Cambridgeshire County Council

Comments on the Applicant's D3 and D3a submissions

This document sets out the comments on the Applicant's Deadline 3 (D3) submissions by Cambridgeshire County Council (CCC). The tables below set out the document in question that the Council is commenting on, together with the relevant paragraph or reference number.

Plate 2: A11 / La Hogue Road Junction

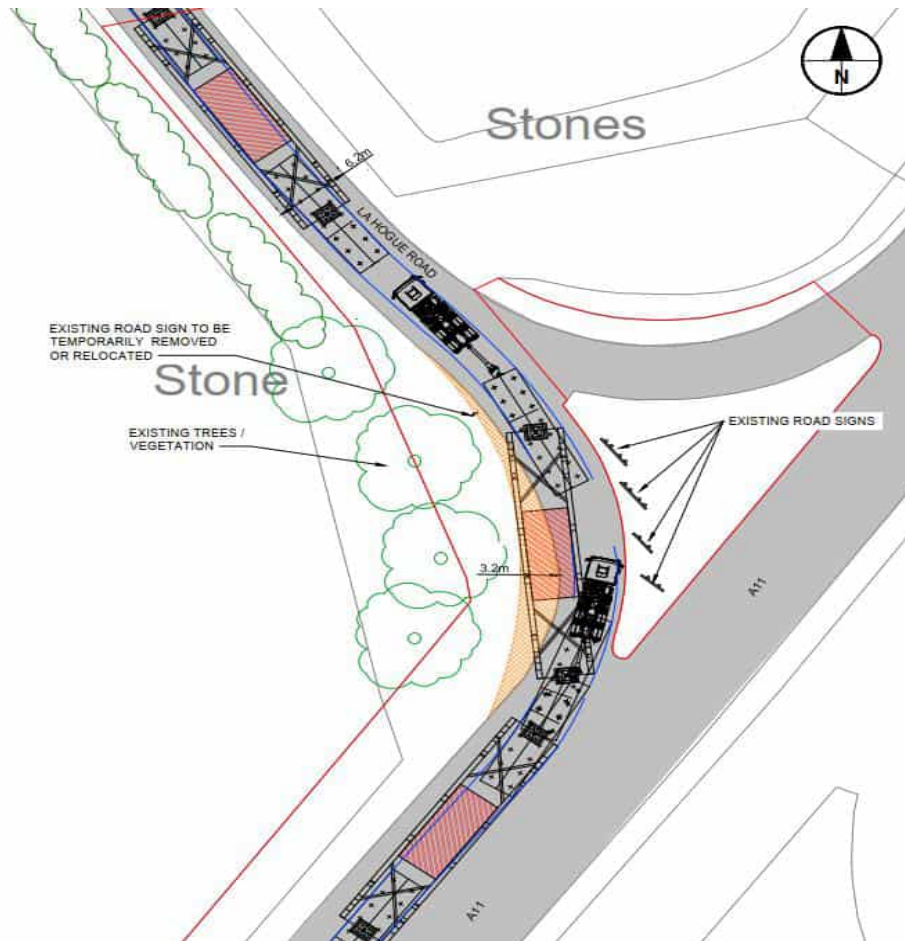
5.2.7	Guidance on passing width in Manual for Streets is not considered by CCC appropriate for setting safe width on high-speed non-residential roads. While the issue is to be discussed

separately with the applicant, the suitability of providing passing places along La Hogue Road in locations where widths are wide enough for the passage of some vehicles may result in drivers of larger vehicles following other smaller vehicles through narrow sections of road without utilise passing places; this risks conflict and overrun. It is recommended that La Hogue Road be suitably widened along the route into the main site access.
